Planning Inspectorate

Application by Springwell Energyfarm Limited for an Order Granting Development Consent for the Springwell Solar Farm

Issue Specific Hearing 3

Action Points:

**TITLE:**  
FIGURE 3.3A  
GREEN INFRASTRUCTURE PARAMETERS  
KEY PLAN

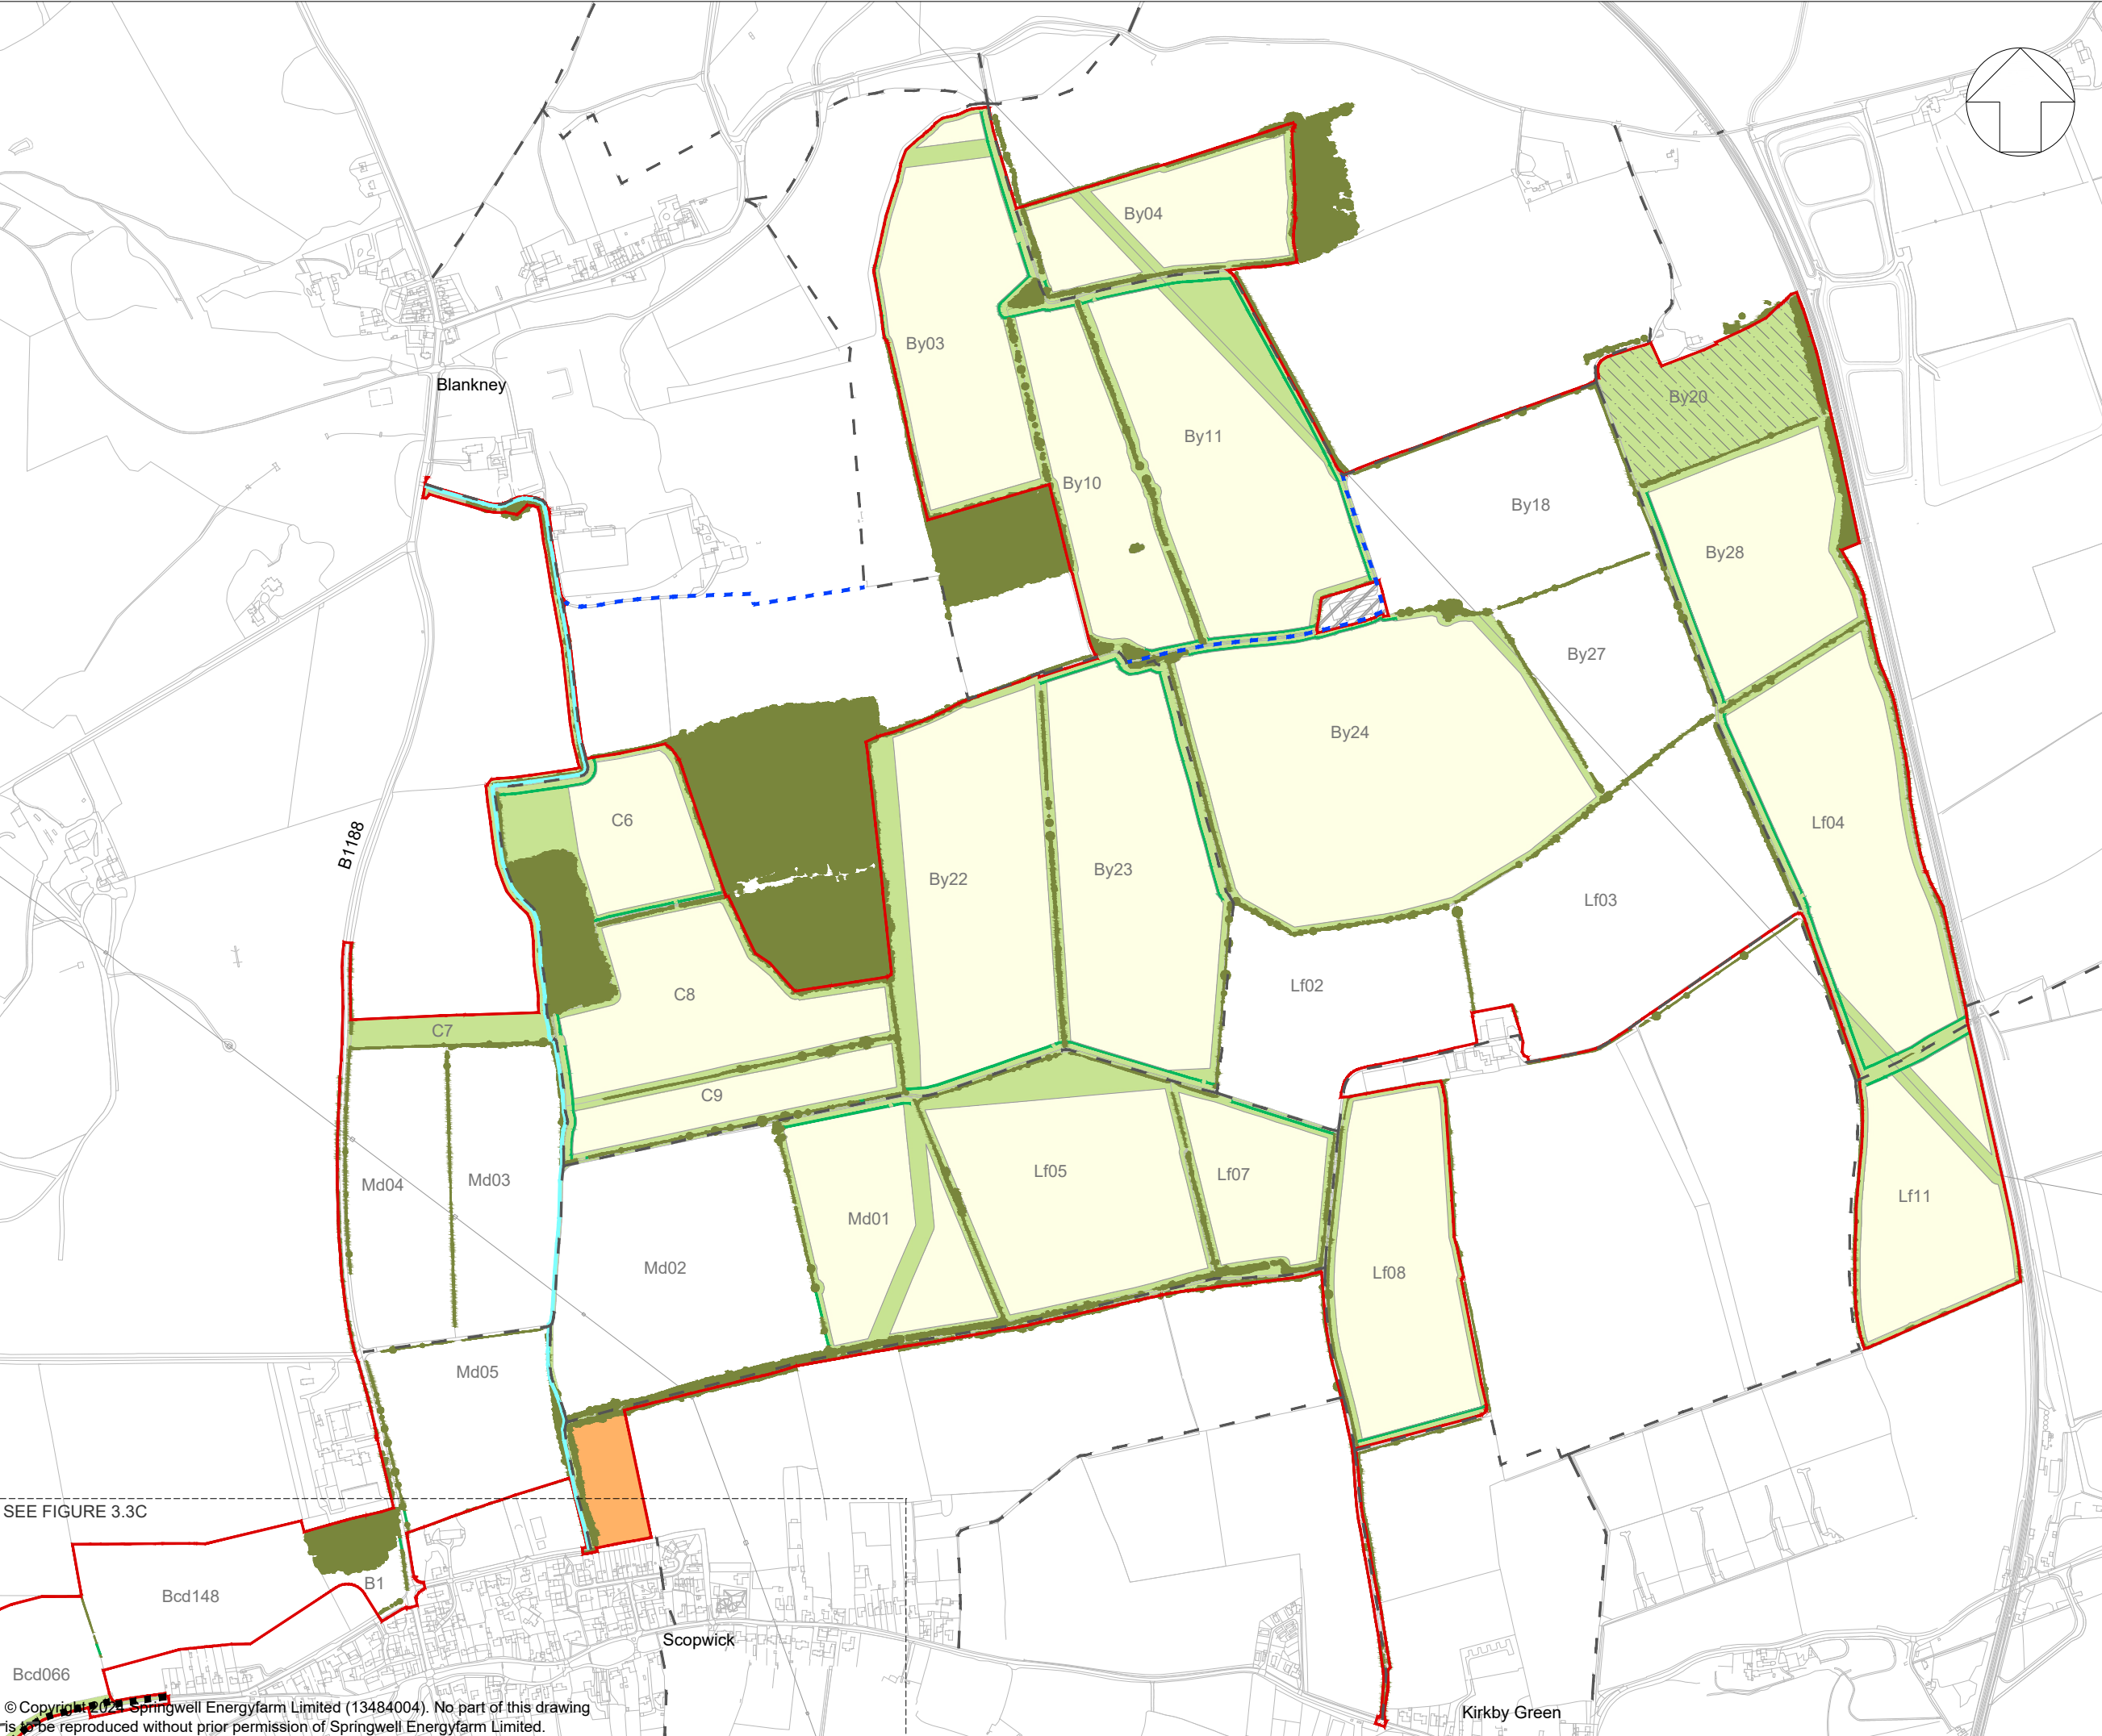
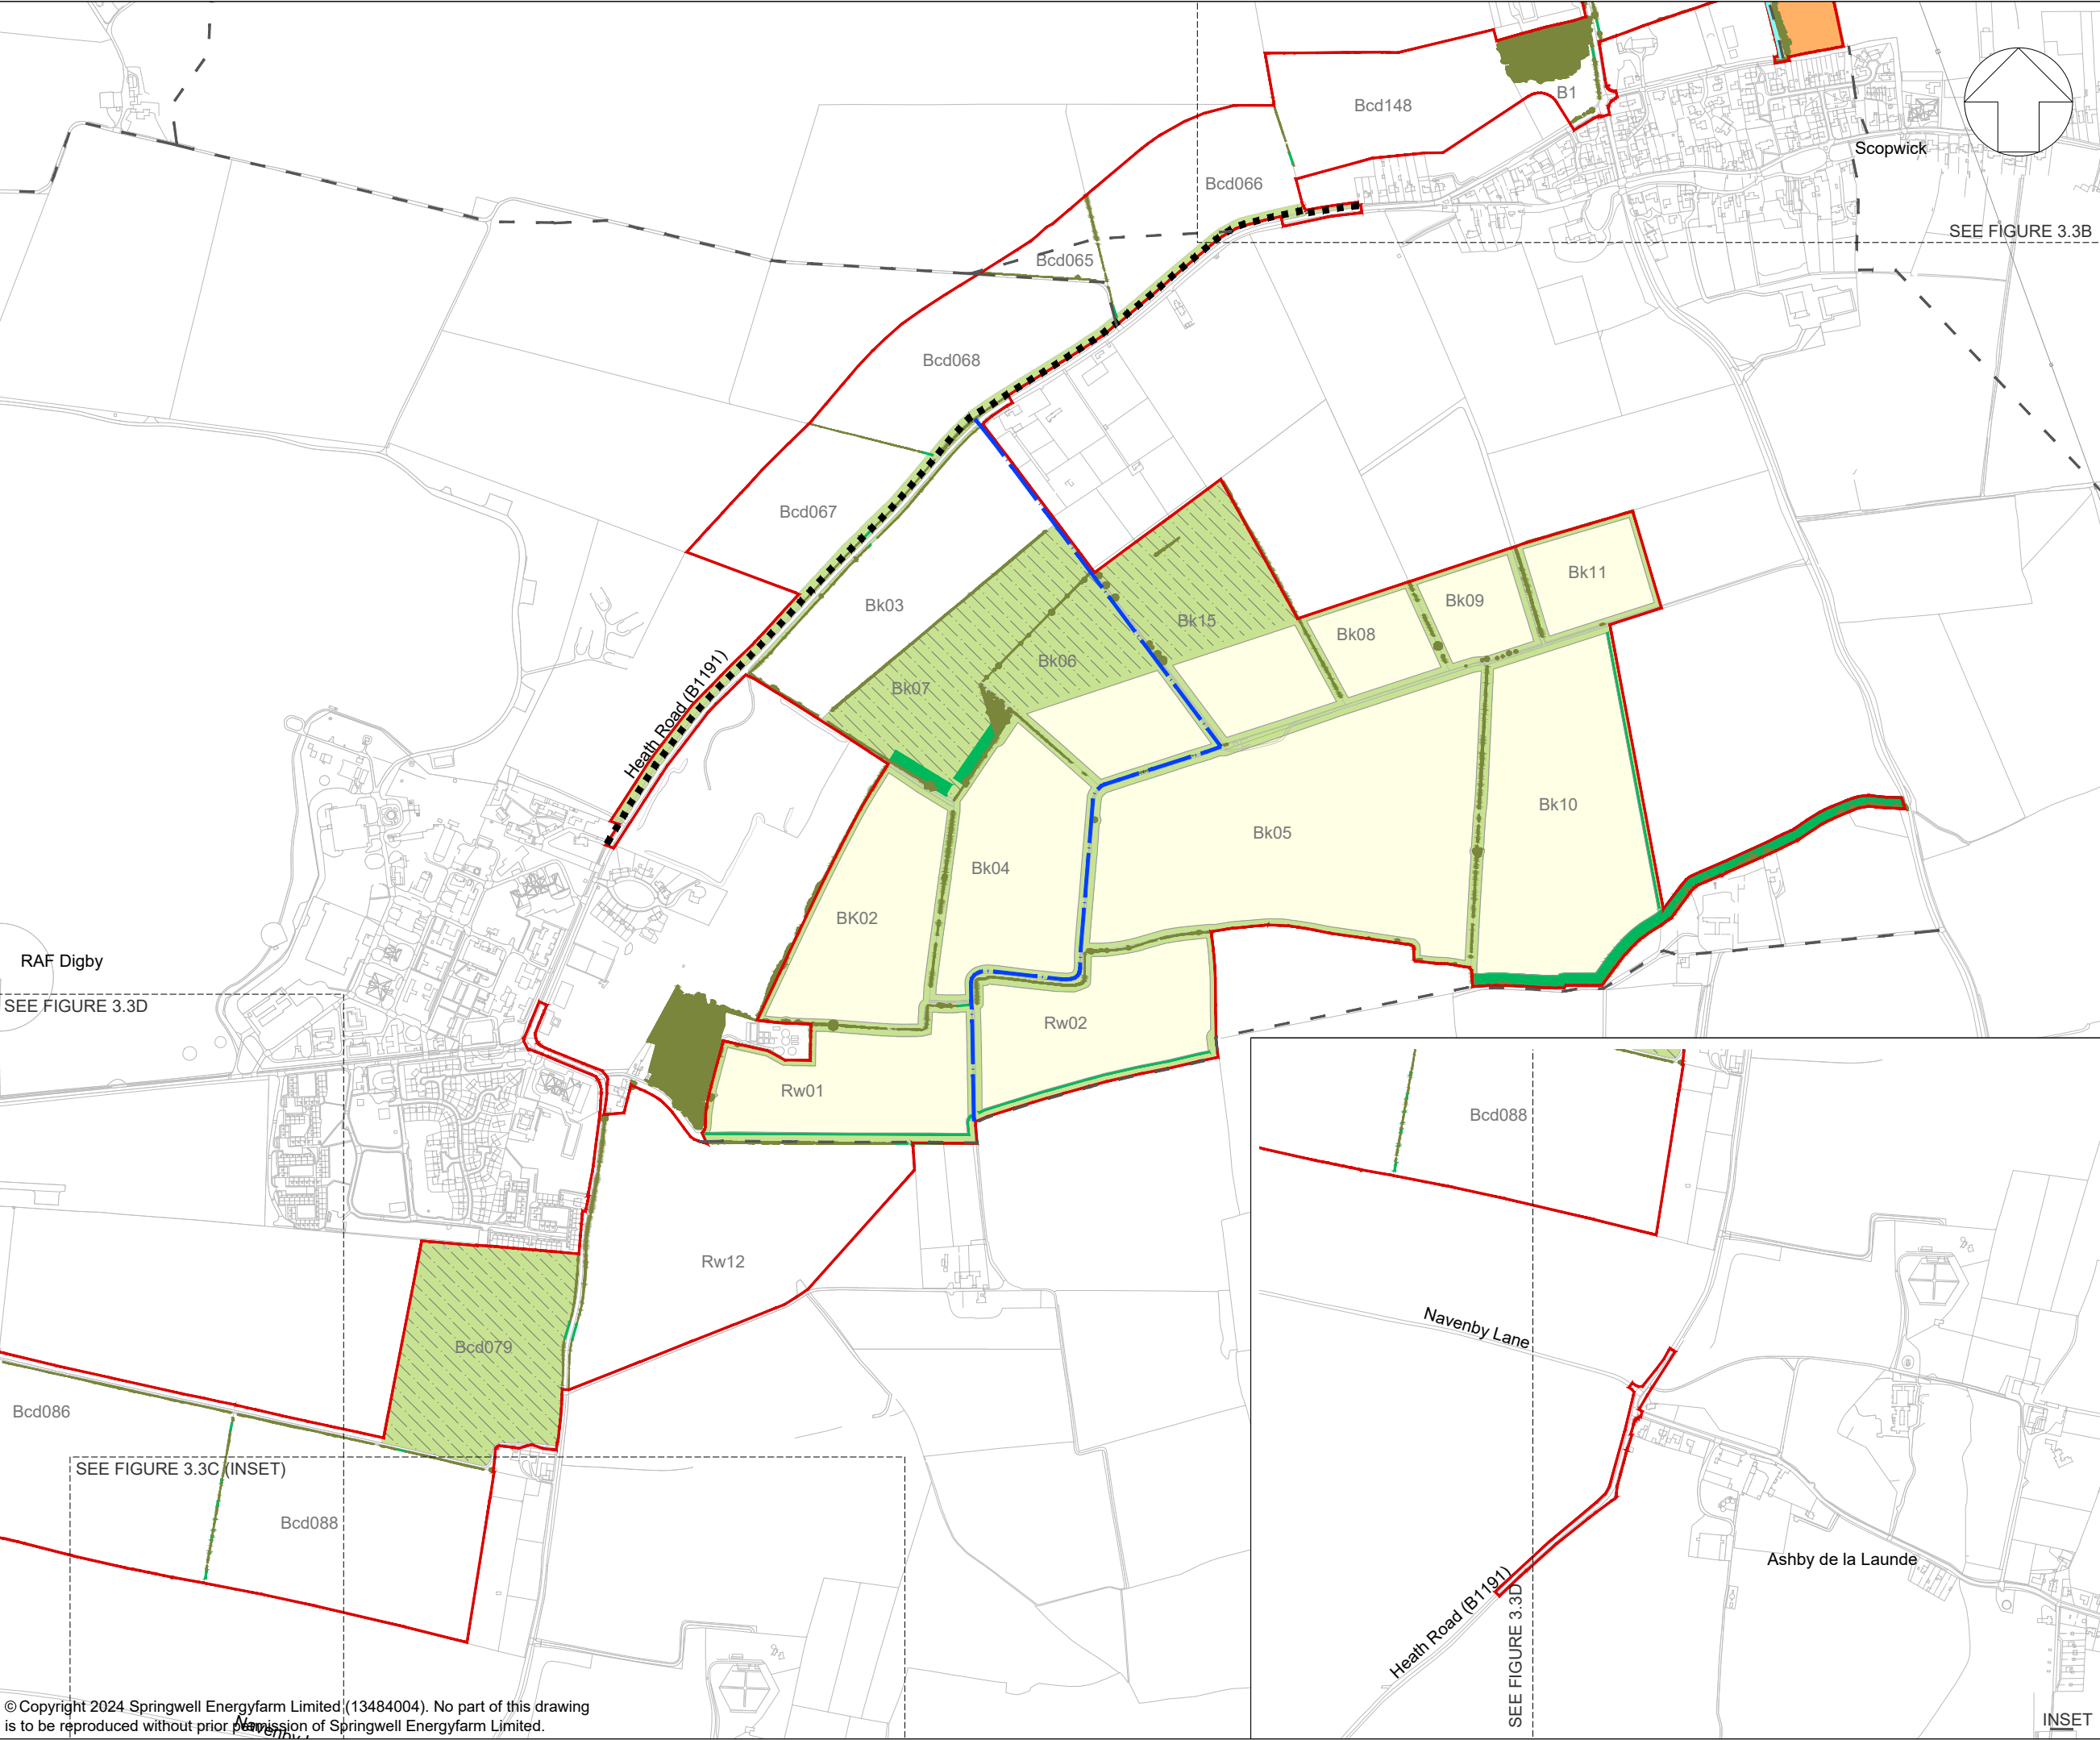
No.	Party	Action	Deadline
		'sealed over' land has been considered as a permanent impact.	
10	Applicant / EA	To have further discussions on wording relating to unexpected contamination	D3
11	Applicant	Scarce Arable Flora - Confirm whether the green infrastructure margins in field Bcd115 shown on the green infrastructure BNG parameters should extend to the north-east corner of the field to include target note location 9 and also whether the proposed strategic tree belt clashes with target note location 10.	D3
12	Applicant	Provide map showing location of proposed mitigation works for ground nesting birds.	D3
13	Applicant	Provide revised dDCO including anticipated BNG figures in Requirement 8.	D3
14	Applicant / NKDC	Further discussions to take place in relation to the data used to assess tourism effects and monitoring measures that could be put in place to understand the impact on tourism related to the use of PRow and stepping out network.	D3
